Department of Planning and Environment
4 Parramatta Square, 12 Darcy Street
Parramatta NSW 2124

Your Ref SSD-10416

14 September 2023

**COUNCIL SUBMISSION
NOTICE OF EXHIBITION OF MODIFICATION REPORT NO. 2 FOR THE PARRAMATTA
POWERHOUSE (30B PHILLIP ST, PARRAMATTA)**

Level 3

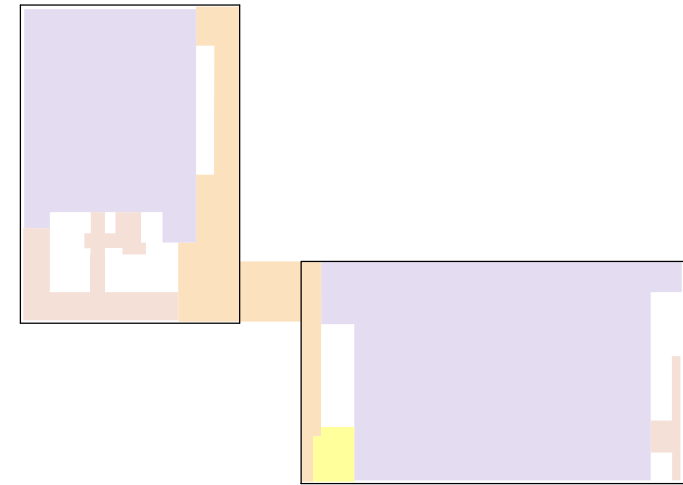
The amendment to the level 3 building façade is not supported; whilst it is noted that the GRC panelling is consistently used throughout the rest of the building, the proposed change results in a poorer façade composition. The diagram below, highlighted in yellow, delineates a consistent glazed ribbon in a logical pattern across the facades, that is interrupted by the proposed modification (see below in red). It is recommended that the glazing is not replaced by GRC panelling. Hiding of servicing and plant could occur behind the glazed element.
